Address: High View, 81, Enfield Drive, Batley, Wf17 8dr

Application number: 2026/90413	
What is the application for?:	Permission in principle for erection of one dwelling
Address of the site or building:	land off, Enfield Drive, Carlinghow, Batley, WF17 8DR
Postcode:	WF12 0LS

PROPOSED SITE LAYOUT Scale 1:200

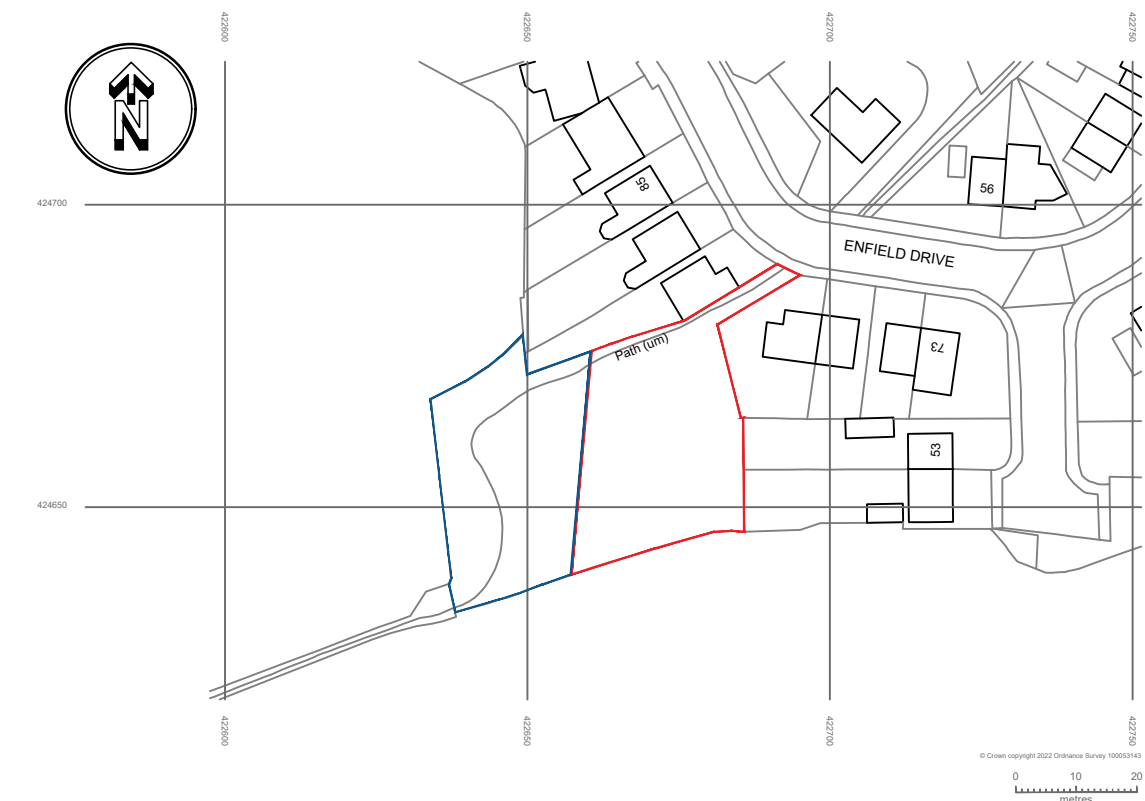
In addition, the proposed access to the development is of particular concern due to its very close proximity to my property. The location of the access point could increase noise, traffic movement, and disturbance directly next to the house, which would further impact our privacy and day-to-day living conditions.
